Our Ref: AA/0/19/HH

**Town & Country Planning Act 1990 (as amended)
Town & Country Planning (Development Management Procedure) (England) Order 2015
Application for Planning Permission for Works or Extension to a Dwelling**

Development Single storey rear extension
Location 2 Manser Villas Westergate Street Westergate

DRAWING	SCALE
PLANNING	1/100
DATE: MAY 2019	
DRAWN: T. Murray	
DRAWING: 19/32/2	REVISION:

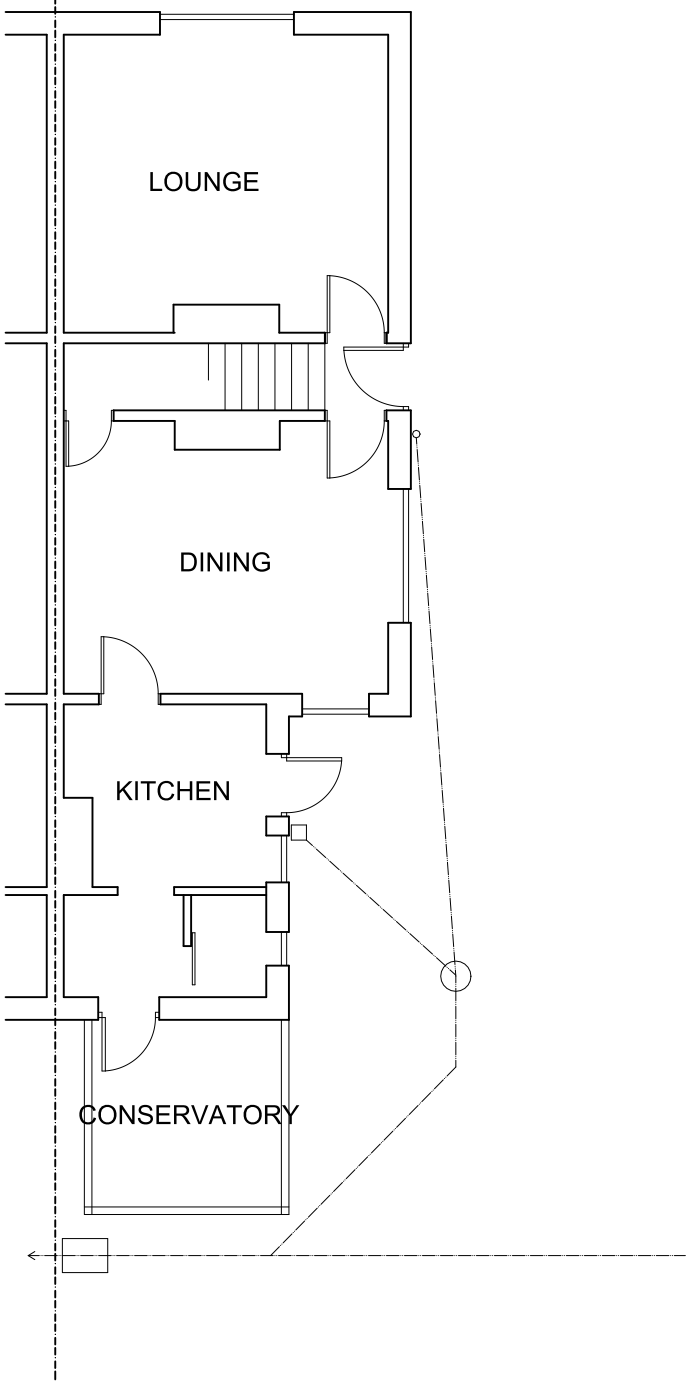
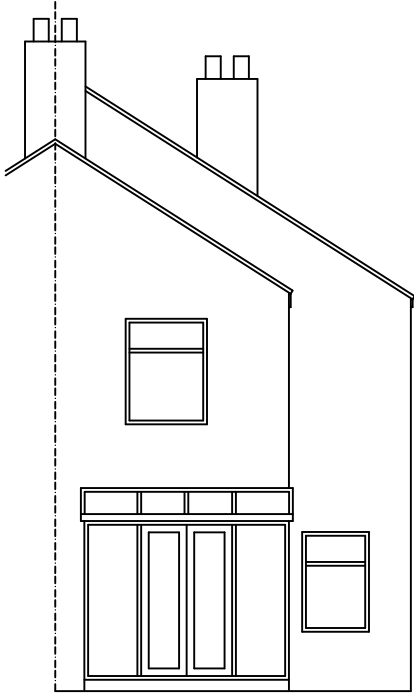
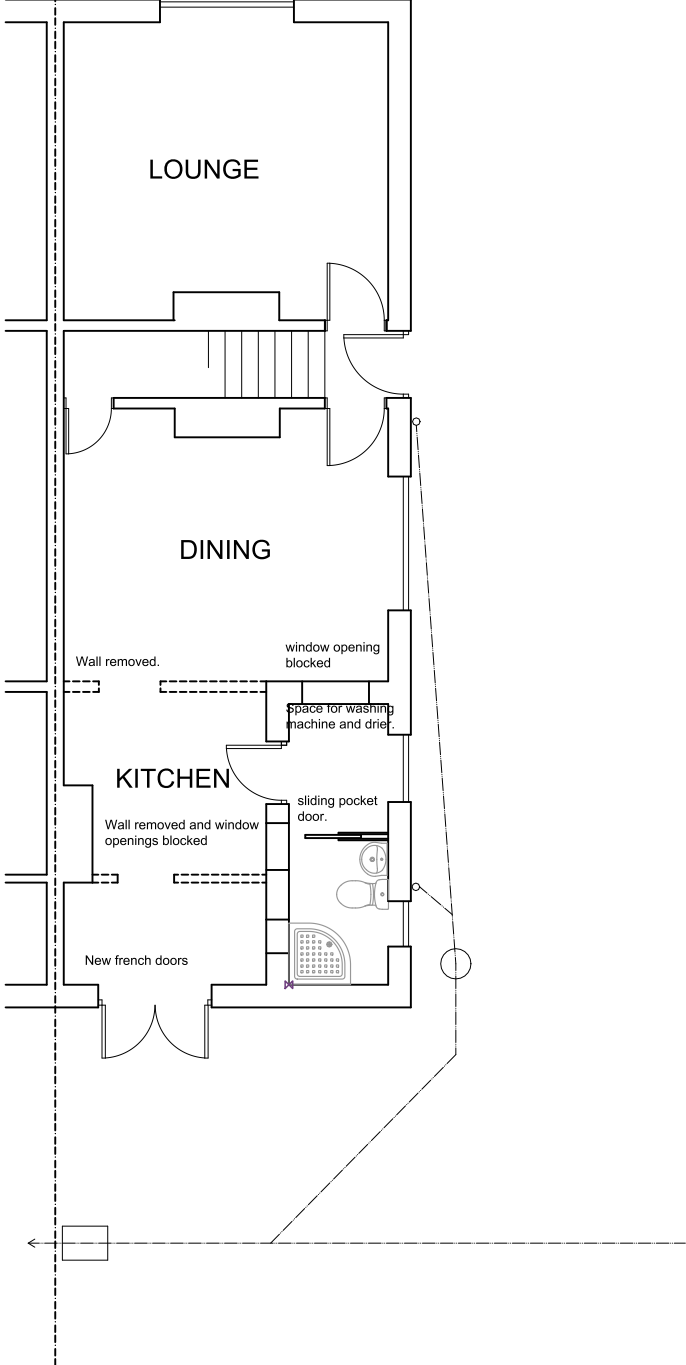
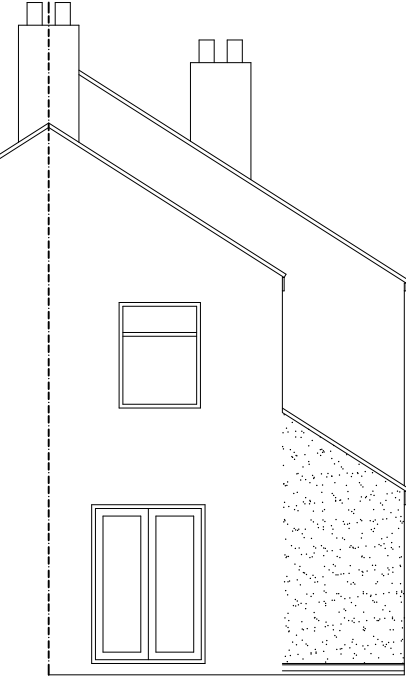
Scale Bar Req'd

Please show a scale bar or dimension on the plans to allow confirmation of the stated scale.
